From: Paul Cann <Paul.Cann@arun.gov.uk>
Sent: 23 September 2022 15:13
To: Planning.Responses <Planning.Responses@arun.gov.uk>
Cc: Katie Sharp <Katie.Sharp@arun.gov.uk>
Subject: RE: Planning Consultation on: BE/53/22/DOC

Application No: BE/53/22/DOC
Registered: 26th May 2022
Site Address: Unit 9 Salt Box Field Land off Rowan Way Bersted PO22 9NW
Description of Works: Approval of details reserved by condition imposed under BE/135/18/PL relating to conditions (Full Application) 14-Maintenance and Management of Surface water drainage, 37-details of all fixed plant, machinery and equipment associated with air moving equipment & details of PVs

Planning Reference: BE/53/22/DOC

At this stage we would not recommend discharge of conditions until the following comments are addressed in relation to conditions 12- Maintenance and Management of Surface Water

Hydrobrake Manhole in Tubosider Tank
Construction Detail

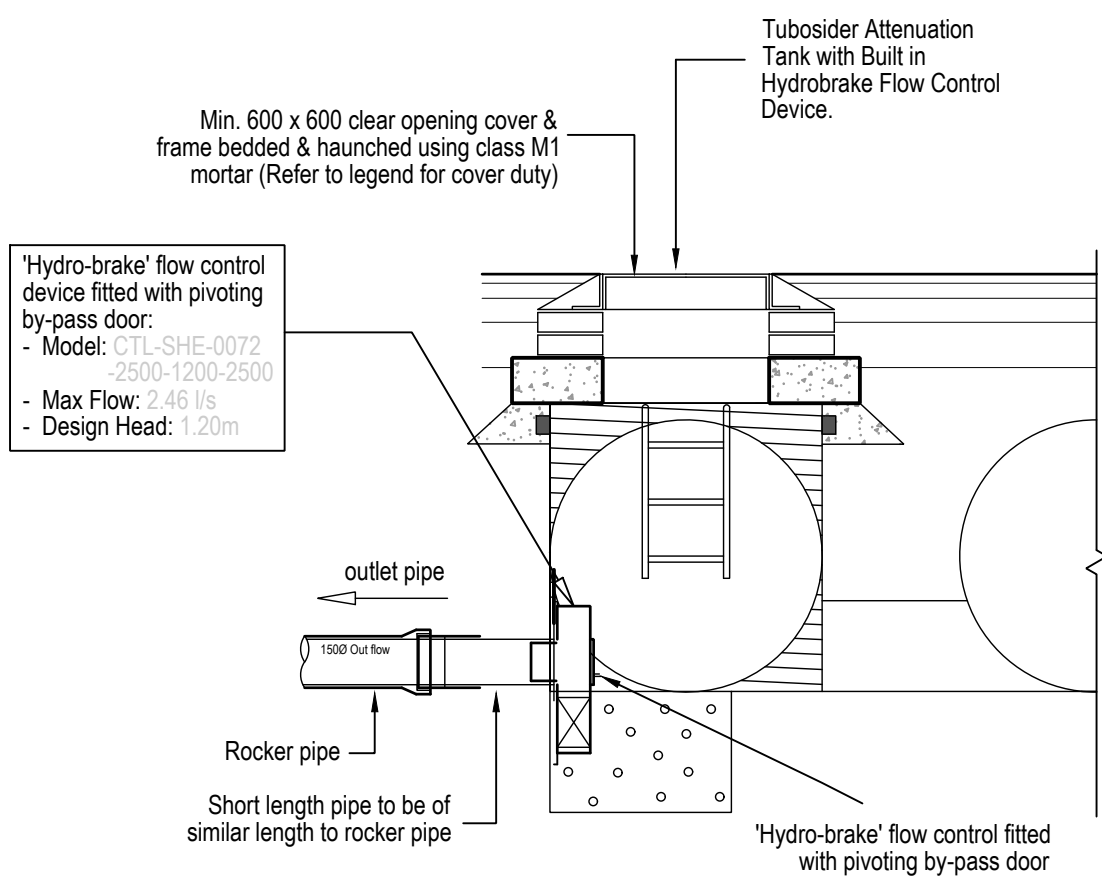
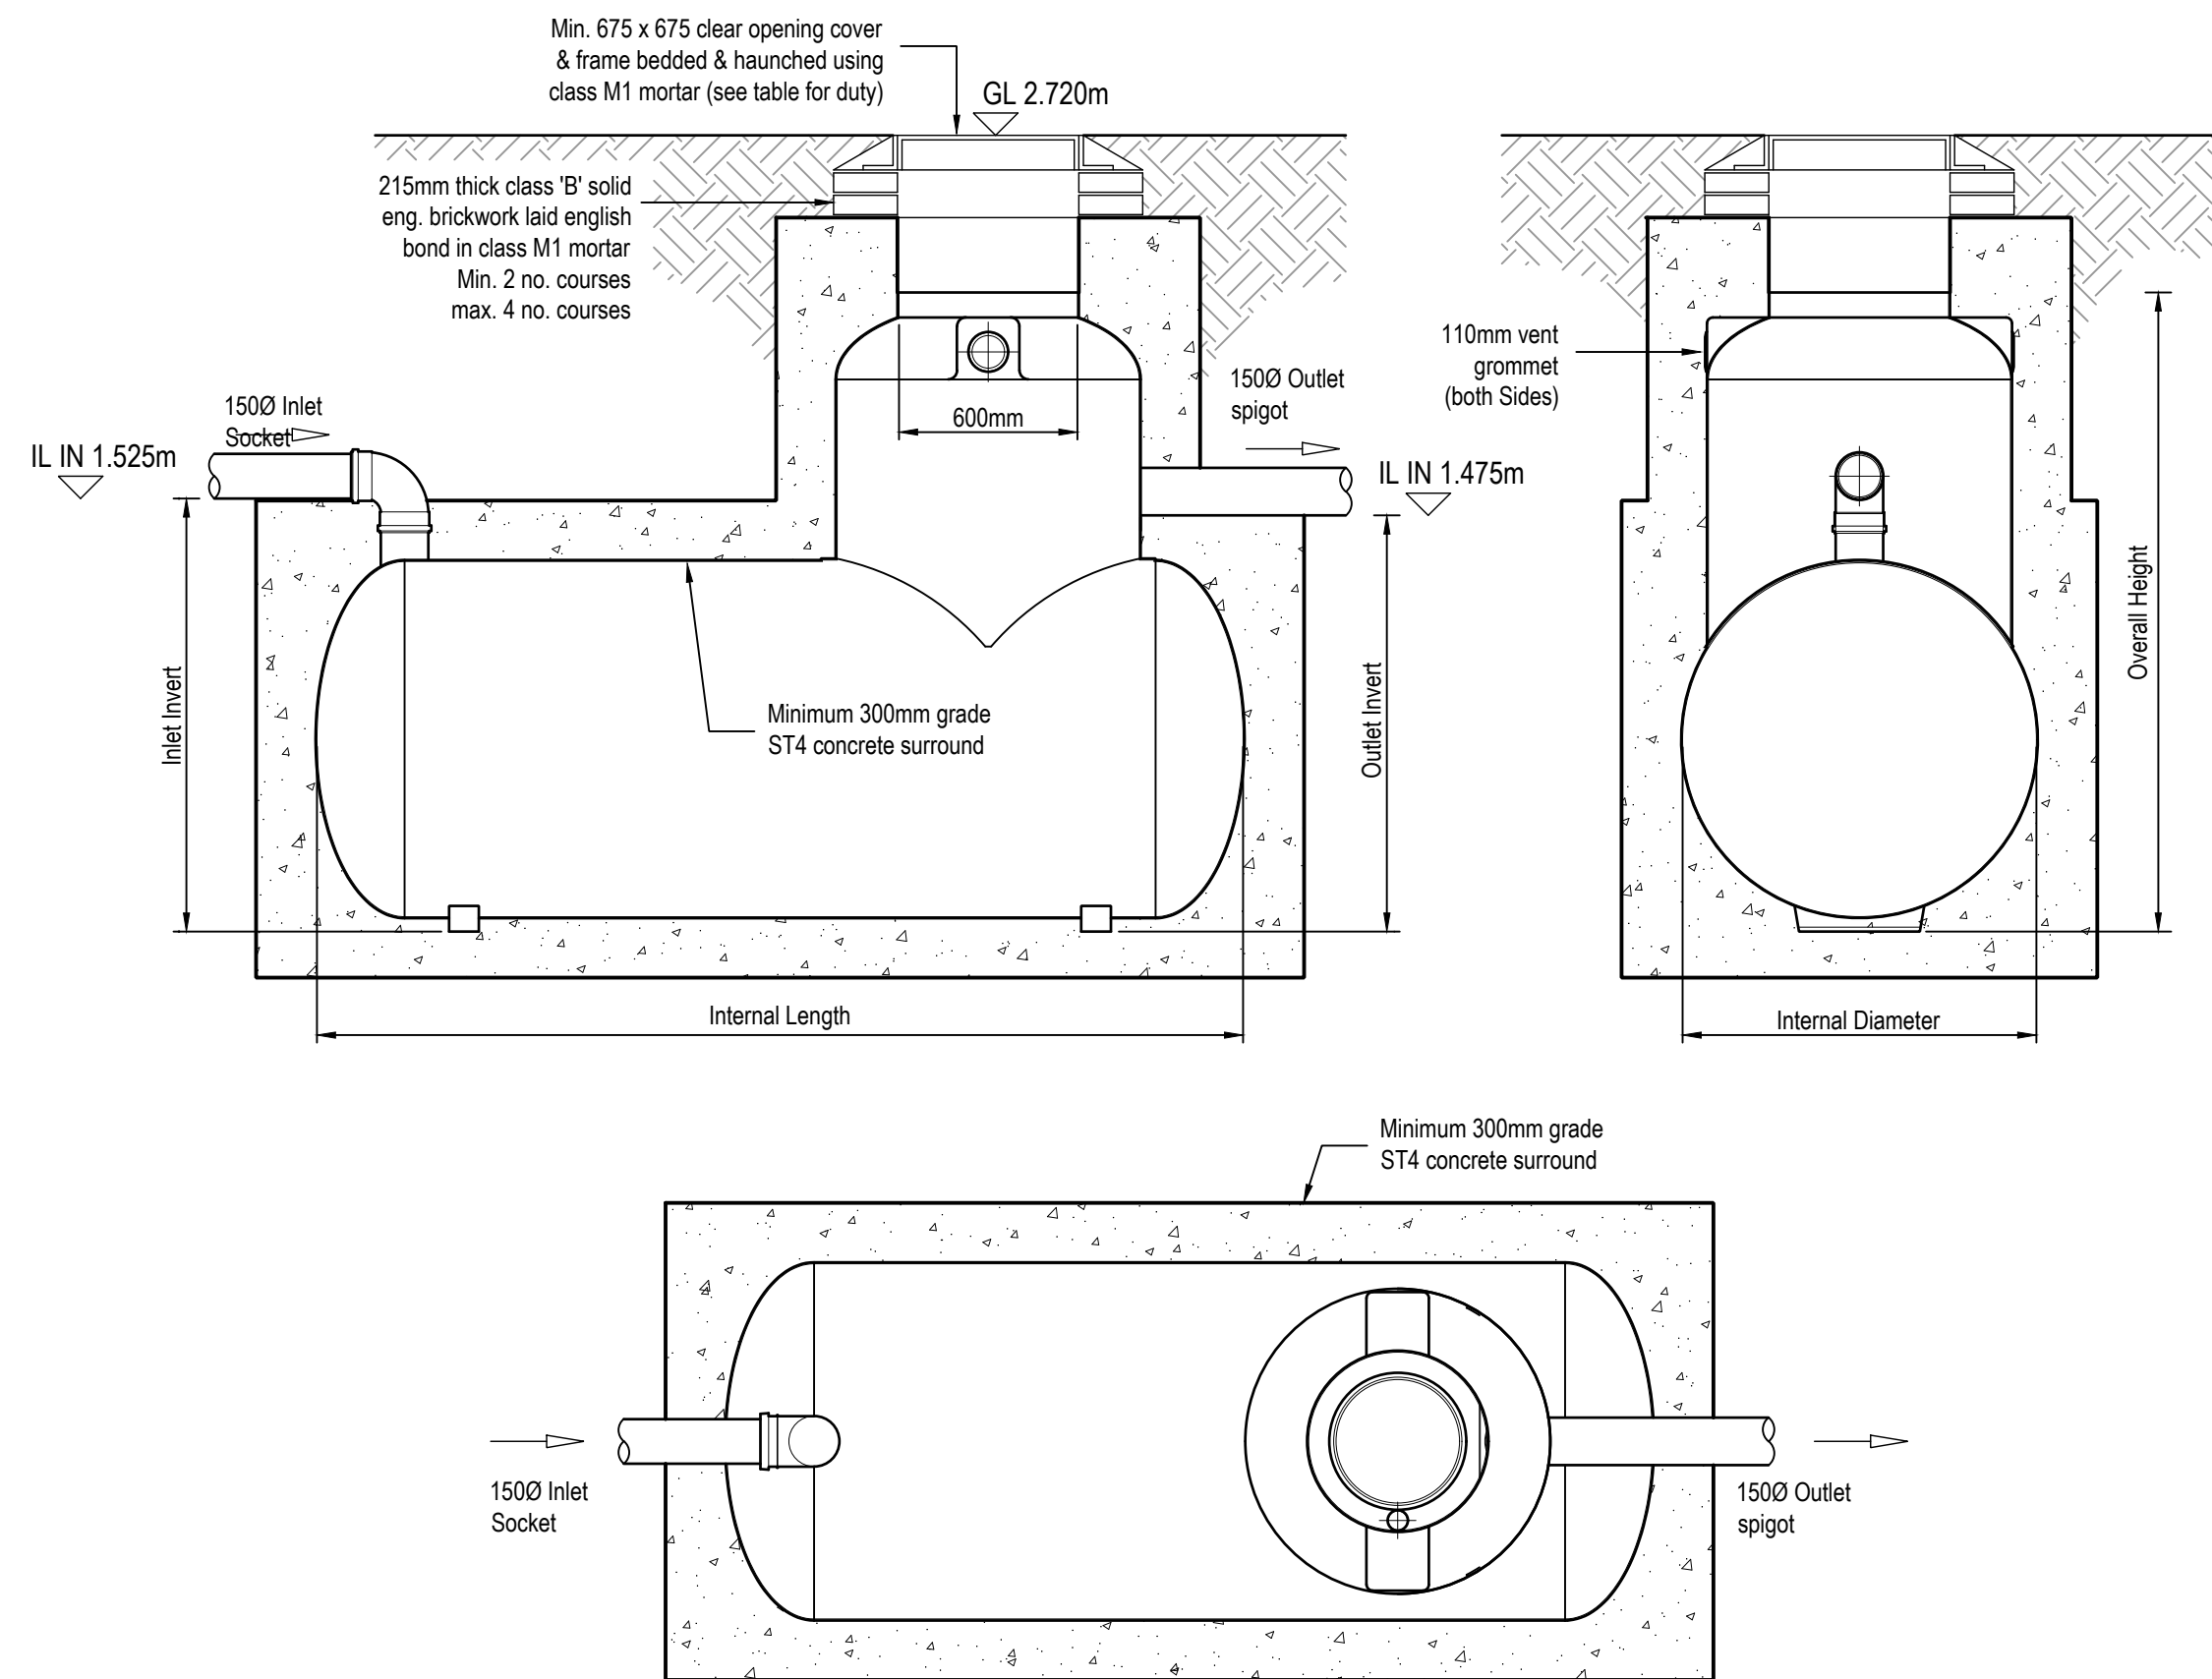
The typical construction detail of the washdown and silt separator on drawing 114378-CAL-XX-XX-DR-D-0503-C is unacceptable. The construction detail should be provided for the actual separator being specified and clearly indicate invert levels of pipe connections and cover levels

A construction detail on the Hydrobrake manhole needs to be provided and showing clearly how it ties into the proprietary attenuation system, this is important to ensure that future maintenance requirements within this manhole is clear
